Comments for Planning Application 21/00796/H

Application Number: 21/00796/H

Address: 8 Canowie Road Bristol BS6 7HS

Proposal: Single storey rear extension.

1
(10)05
GROUND FLOOR PLAN AS PROPOSED
1:100

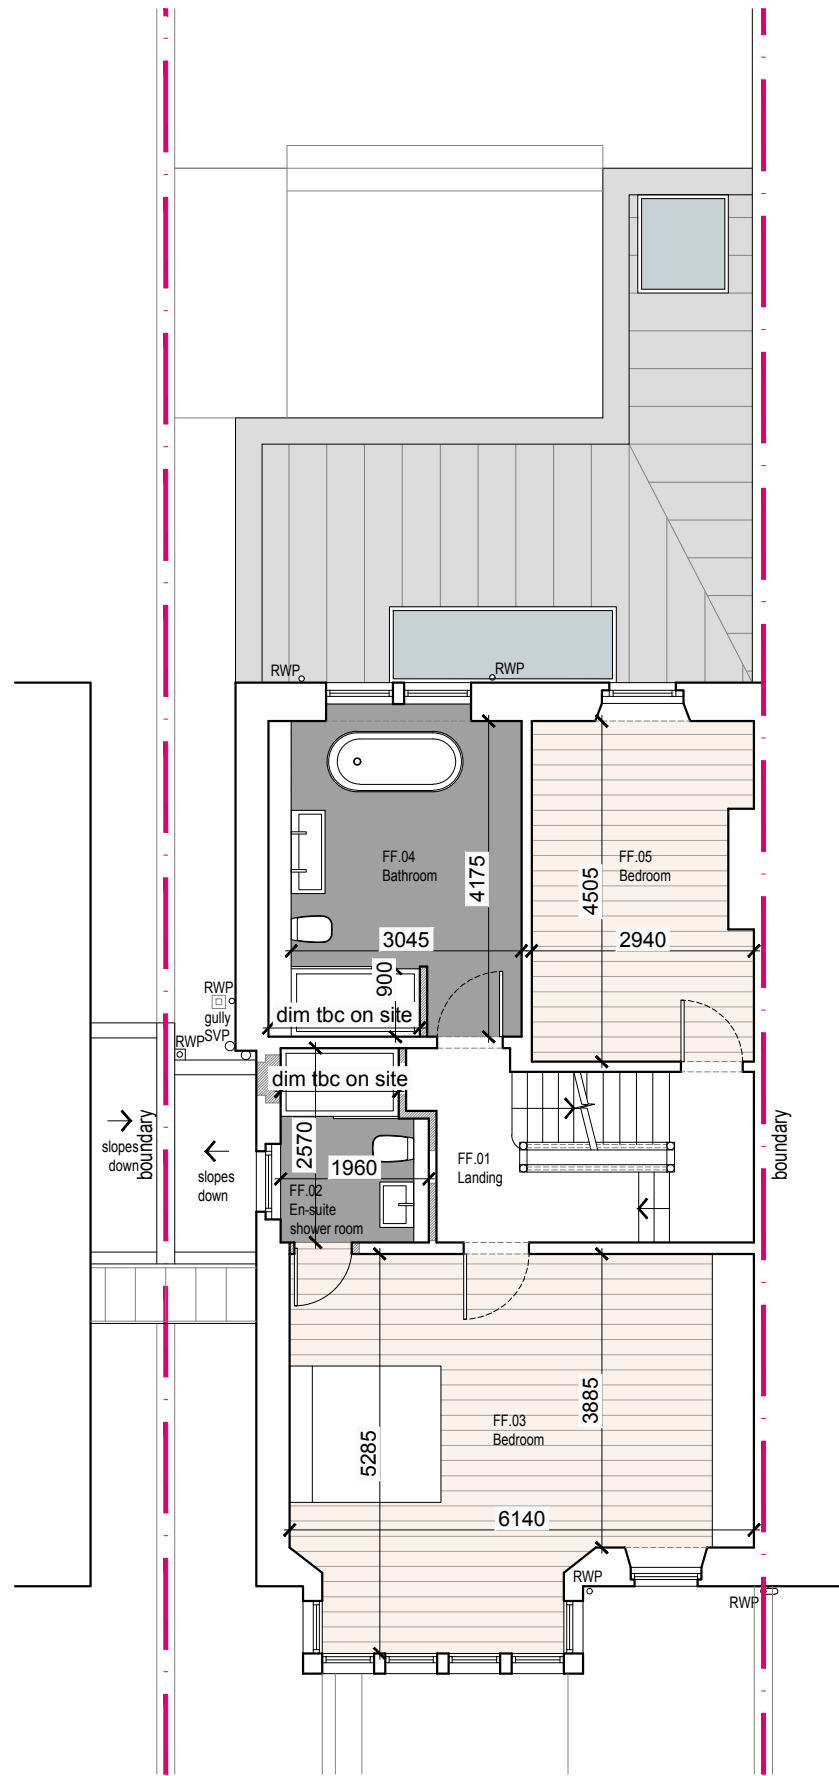
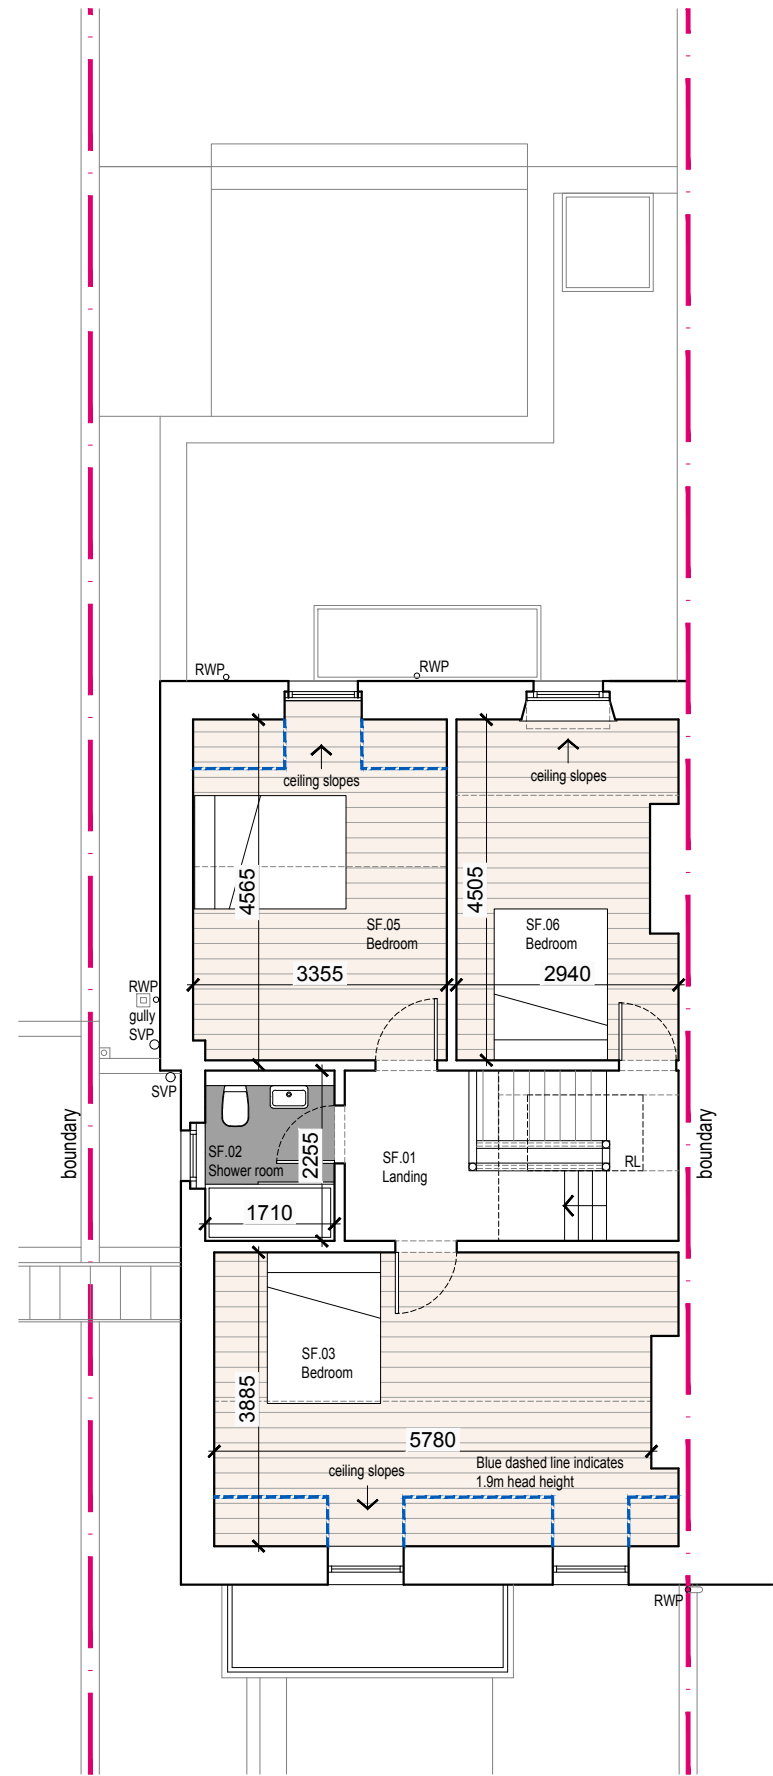
1) The proposed single storey extension would extend 3.5 metres from the existing rear wall. This would reduce light to our rear ground floor windows between about 11 AM and 3 PM and this would be more noticeable during the winter months when the sun is lower in the sky.

2) In addition, although we are not in a Conservation Area we are unhappy about the proposed removal of the existing rear bay window. All other properties on this side of Canowie Rd retain their original bay windows.
